Application No: EP/10/21/PL
Site Address: 4 Beechlands Close & east of 18 Beechlands Court Montpelier Road, East Preston BN16 1JZ
Description of works: Demolition of an existing garage & erection of 2 No. 2 bed dwellings (resubmission following EP/115/20/PL). This site is in CIL Zone 4 and is CIL Liable as dwellings.

OWPC34274

18 BEECHLANDS COURT, EAST PRESTON, BN16 1JZ	
Client	Description
c/o RSP ARCHITECTS LTD	PROPOSED SITE PLAN

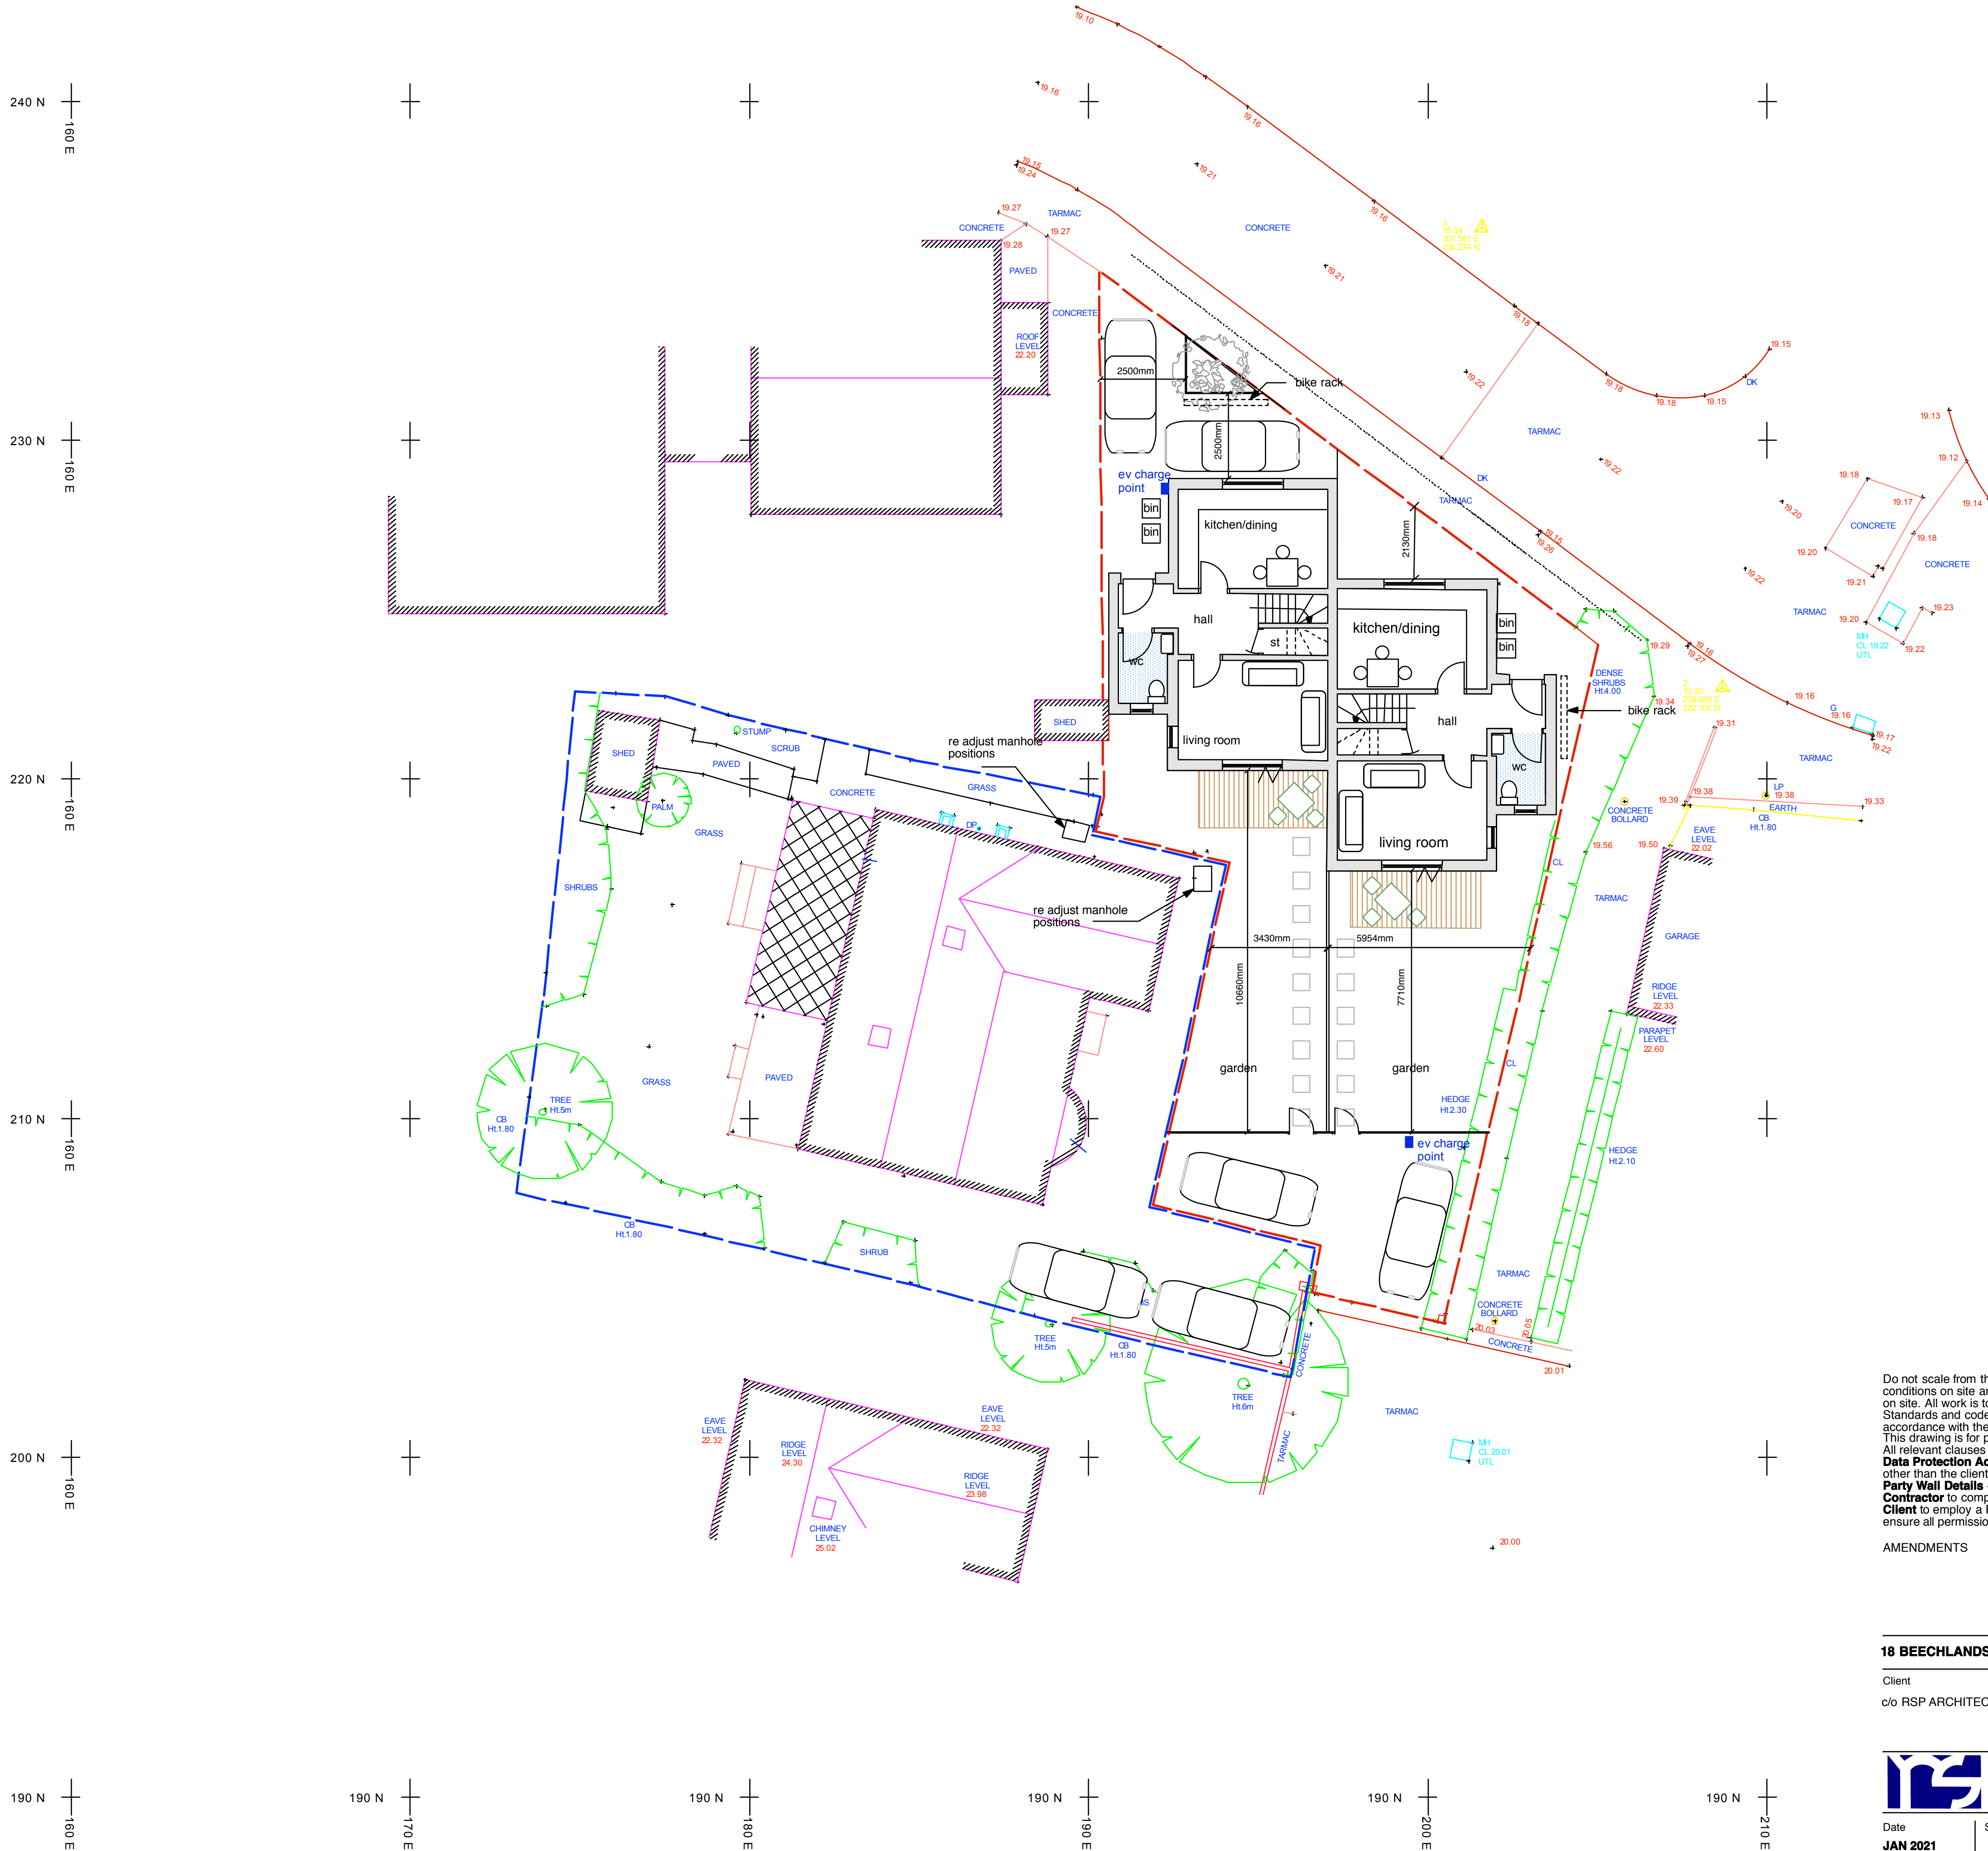
The site of the two houses remains small and constrained between the adjoining houses. The gardens, though larger, are sited between existing houses in a way that would ensure they were overlooked. The close proximity of new and existing houses and gardens would create a development that would provide the new residents with unsatisfactory amenities, and would reduce the amenities of adjoining properties. This impact on adjoining properties means that the development would contravene Policy D DM1.3 of the Arun Local Plan.

The other fundamental objection to this proposal is that the houses are of two storeys. The East Preston Neighbourhood Plan specifies, in Policy 3, that development proposals in this part of the village (Character Area 2) should be no more than 1.5 storeys high. This area is predominantly a bungalow development, and the objective of the Plan is to maintain a consistently low building height.. The two storey houses would also contravene Policy D DM1.1, because they would not reflect the character of the surrounding area.
